## Department of Planning and Environment

Letter to Applicant  
(consent granted)

Our reference:22/01616  
LOC No: 632206

<b>Consent for Development Comprising:</b>	Construction and Operation of a Large-Scale Solar Farm (SSD-13166280)
<b>Crown Land</b>	Lot 1 & 2 DP 1154765 Lot 1 DP 456698
<b>Crown reserve</b>	Crown road
<b>Parish</b>	Currandooley
<b>County</b>	Murray
<b>Applicant</b>	Dominic Osborne

Figure 2 January 2022 Design Layout of the Project

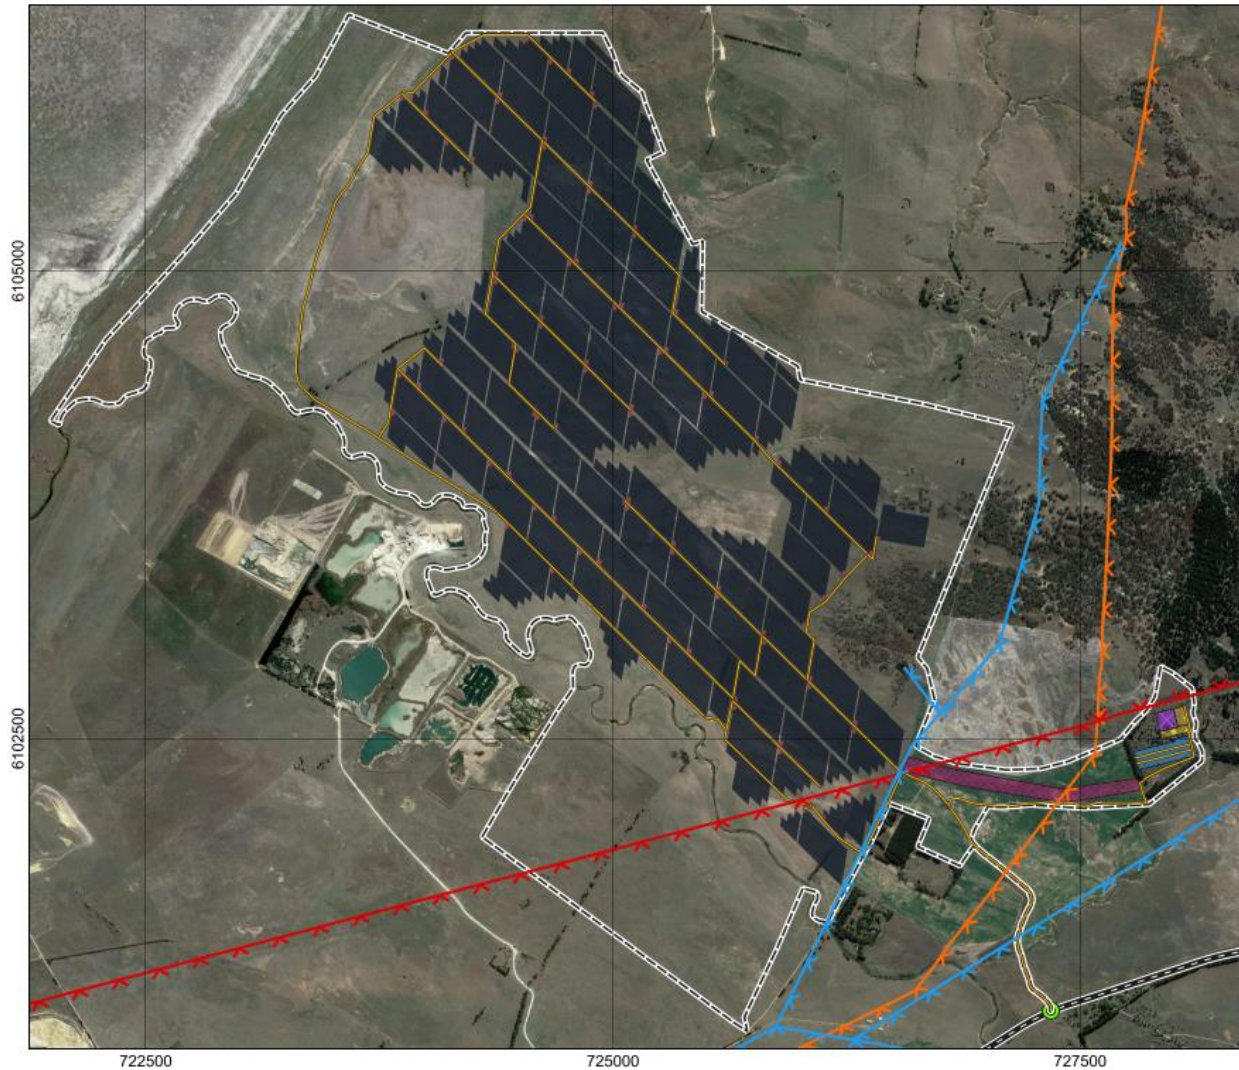
On review of the site plan submitted with this LOC it appears to show solar panels across the Crown road in Lot 2 DP 1154765 as well as an easement for underground cables under a section of the Crown Road located in Lot 1 DP 456698. It is therefore recommended that consent be sought under:

1. S138 of the Roads Act 1993 prior to any works in on or over a Crown road be undertaken,
2. S152A to authorise the occupation or use of Crown roads by works and structures, or
3. S71 to carry out road works for access purposes (S71).

It is further recommended that the proponent lodge an application to close and purchase the Crown Roads impacted by this development.

It was also noted that the location of the Laydown & Site Offices is within the boundaries of Public Road 6141-1603 gazetted as a public road in Gazette 30th Aug 1899 Fol 6531. It is recommended that you liaise with the Queanbeyan Palerang Council on this matter.
